Waste Management Facility, 2-4 Hale St, Botany Landscape Concept Design Report

1.0 Response to Comments

NORTH POINT  
Drawing Title  
**SITE PLAN**  
SHEET NUMBER  
**1220011\_A005**  
ISSUE  
**N**

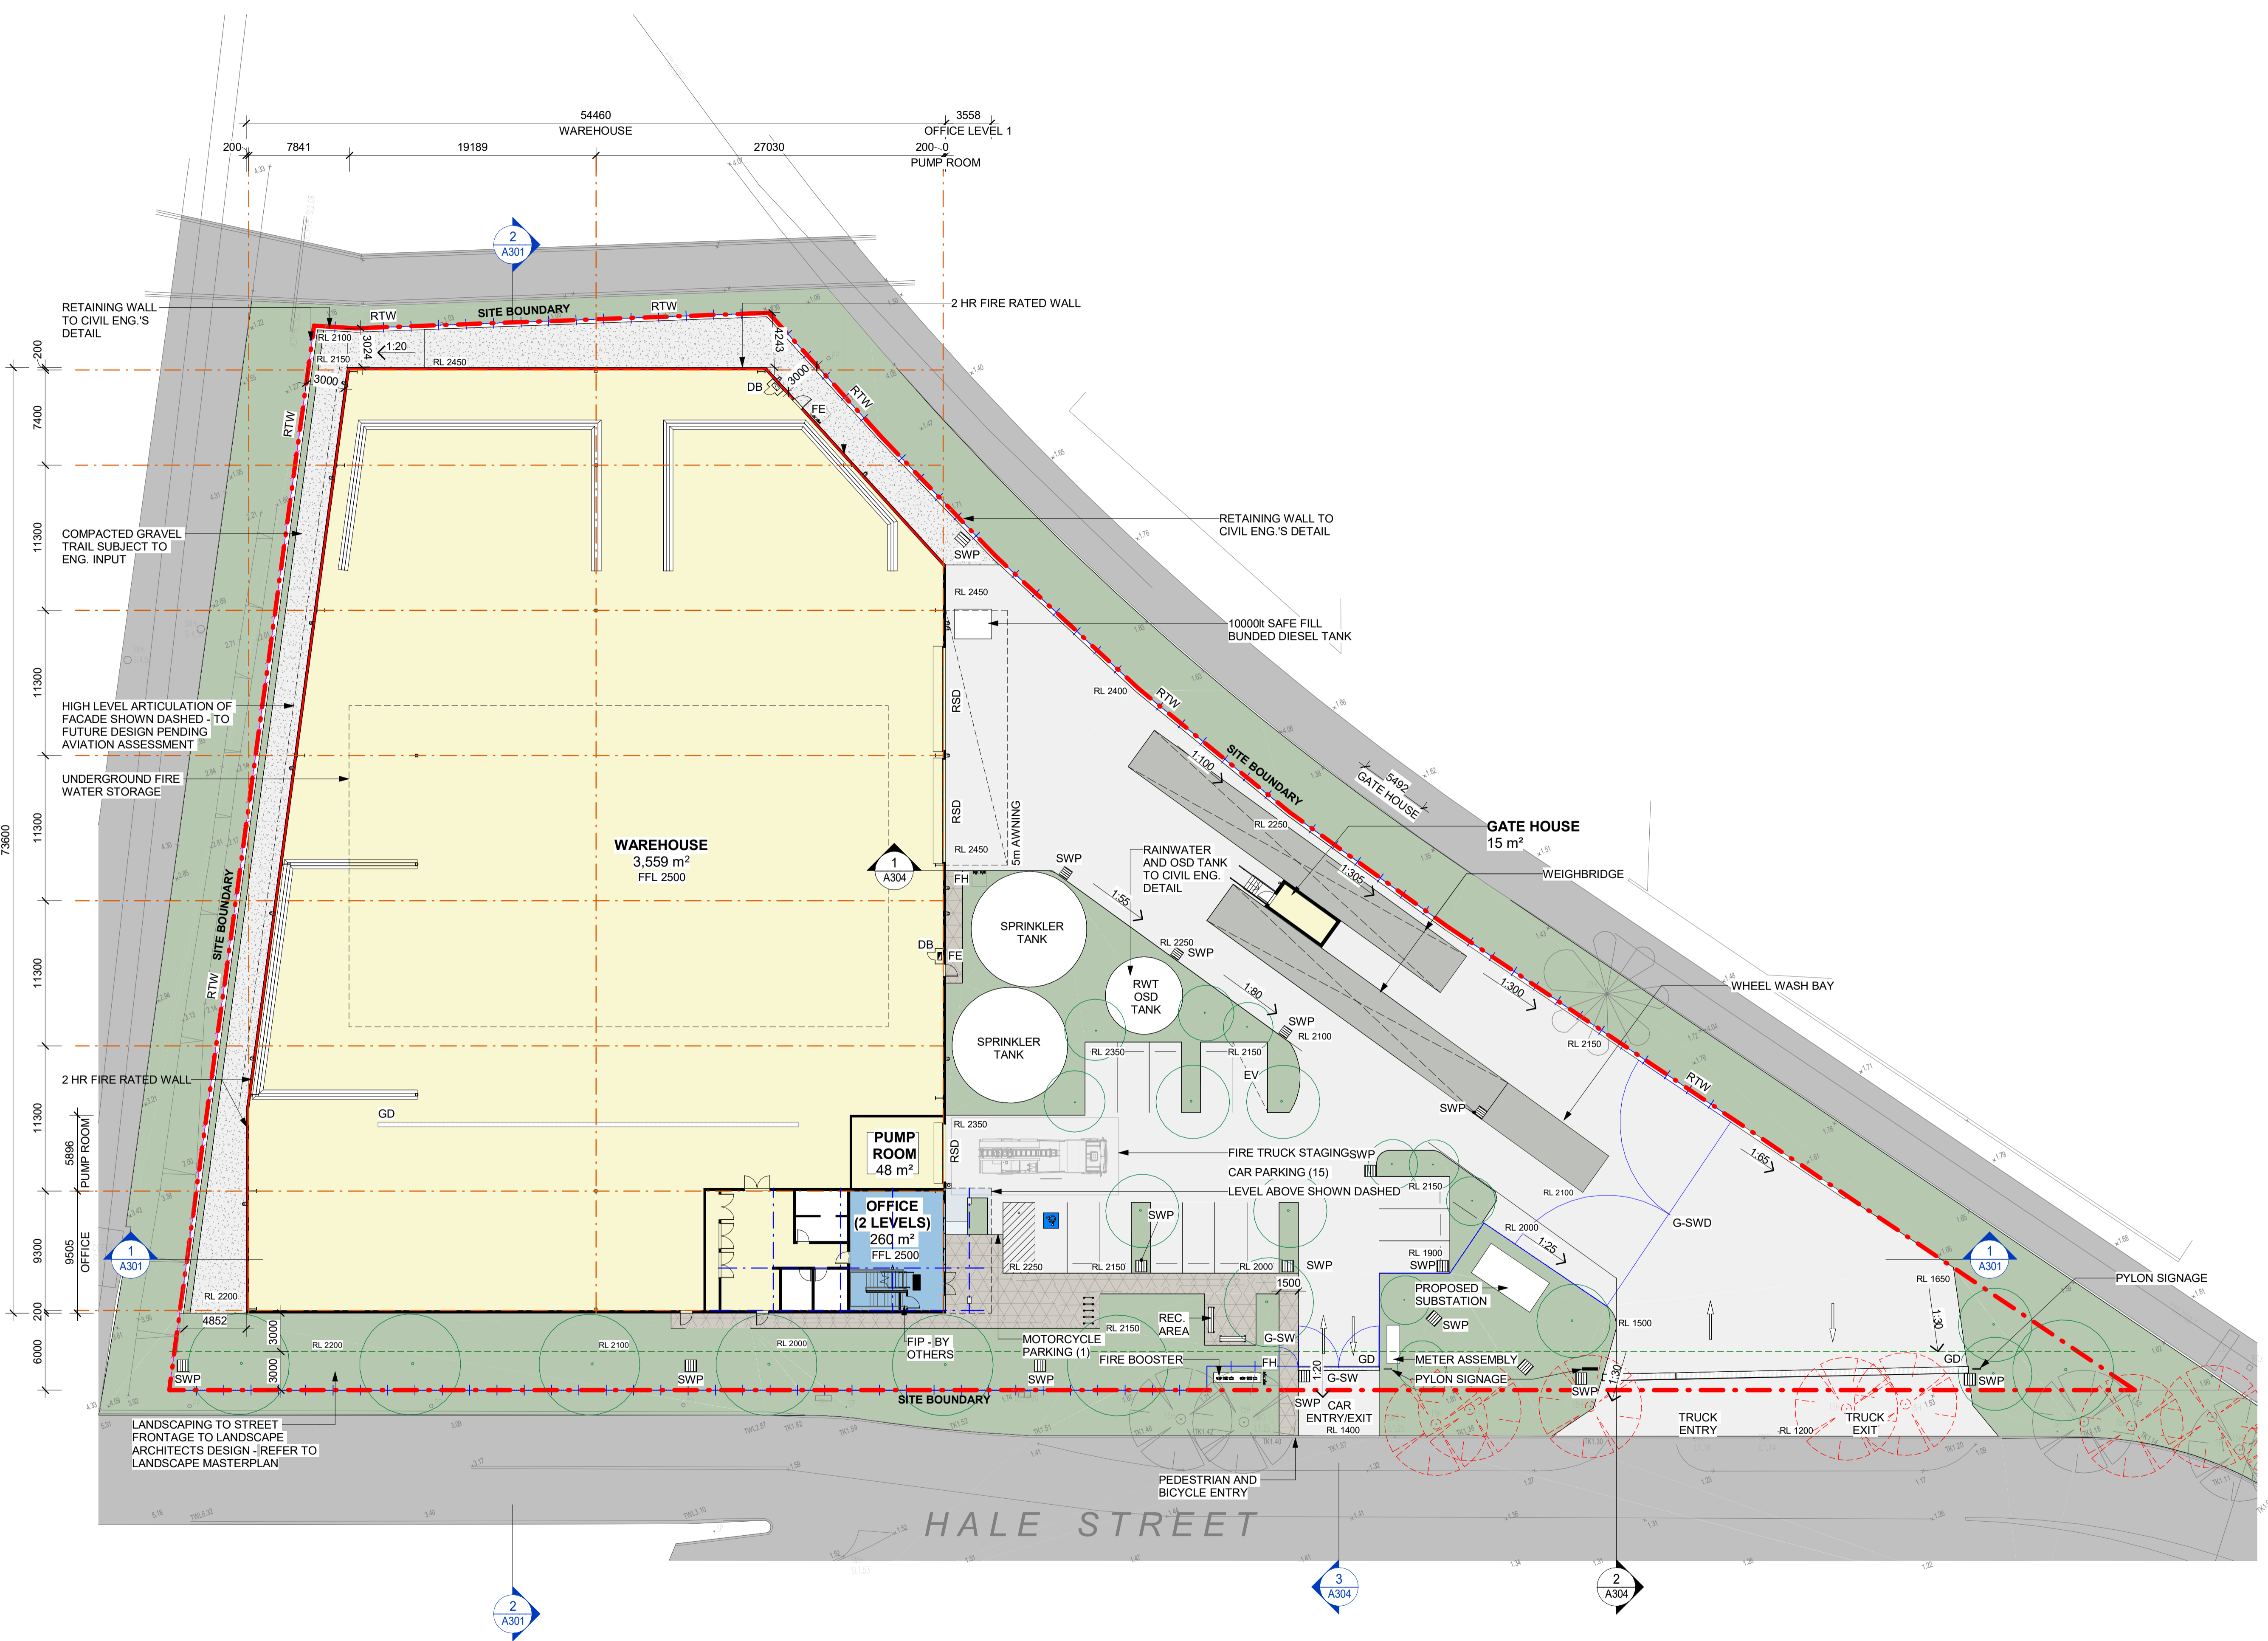
DPHI COMMENT		
DPHI COMMENT	RESPONSE	ADDRESSED ON PAGE:
Inconsistencies The Landscape Concept Design prepared by CJ Arms dated 19 April 2024 includes inconsistencies with respect to the number of semi-mature Casuarina glauca (She Oaks) to be removed, in some places it says four trees will be removed, and in others it indicates five trees will be removed. Recommendations: The Landscape Concept Design must be revised to confirm the total number of trees to be removed as a result of the development.	We confirm these inconsistencies have been rectified. Five trees will be removed as indicated on the Existing and Demolition Landscape Plan, and the Landscape Plan.	6.0 Existing and Demolition Landscape Plan. PG 8 7.0 Landscape Plan. PG 9
COUNCIL COMMENT		
COUNCIL COMMENT	RESPONSE	ADDRESSED ON PAGE:
The landscape concept plan identifies areas of the side and rear setbacks as contributing to the landscaped area. It includes these areas in the calculation of the total landscaped area on the site. However, the plans indicate these side and rear setbacks are to be entirely "compacted gravel". It is not considered that a plain compacted gravel surface satisfies the intention, functions and definition of landscaped area.	We have introduced a planting buffer along the western and northern landscaped areas. This buffer will be planted around the perimeter of the site with the area between the planting and building to be finished with a 2m wide permeable crushed granite or gravel to allow maintenance access for the fence, building and landscape.	7.0 Landscape Plan. PG 9

The proposal does not identify any improvements to the Hale Street public domain. The determination should include a requirement for landscaping improvements to be made to the street.	Hale street public domain improvement/revegetation will be provided to the section of nature strip indicated in the Landscape Plan.	7.0 Landscape Plan. PG 9
It appears that no outdoor space for staff is provided. The Bayside DCP 2022 (6.4: C.6) requires that staff are provided with an outdoor area for recreation, being at least 16m2 in size, with a minimum dimension of 3 metres. At least 6m2 of the area should receive direct sunlight for the hours between 10am and 2pm in mid-winter and be shaded in summer. The recreation area should not be in the landscaped setbacks.	We have created a 16 sqm space (4m X 4m) to achieve this requirement in the revised architectural masterplan.	7.0 Landscape Plan. PG 9
It appears that the car park could be further landscaped. The Bayside DCP 2022 at 3.7.5 requires that at-grade carparks have generous landscaping and tree canopy planting, including:	We have proposed a reconfiguration of the carparking area to maximise canopy coverage in the carpark.	7.0 Landscape Plan. PG 9

1 Tree per 5 car spaces to achieve 50% canopy coverage at maturity to combat urban heat impacts.	There are a minimum of 3 trees (100L pots) proposed within the carpark area (15 car spaces)	7.0 Landscape Plan. PG 9
The car park should feature areas of landscaping to break up functional areas of the car park including pedestrian crossings and entry areas. Contrasting materials should be used to help define these elements visually.	The architectural masterplan and associated Landscape Plan have been updated to address these concerns.	7.0 Landscape Plan. PG 9
Tree pits should provide adequate dimensions to cater for tree roots, future tree growth and to provide adequate moisture penetration and aeration of the root zone.	Noted	
The minimum pot size for trees in the parking area is 100 litres	Noted	
Further details are set out in the Bayside Landscaping Technical Specification.	Noted
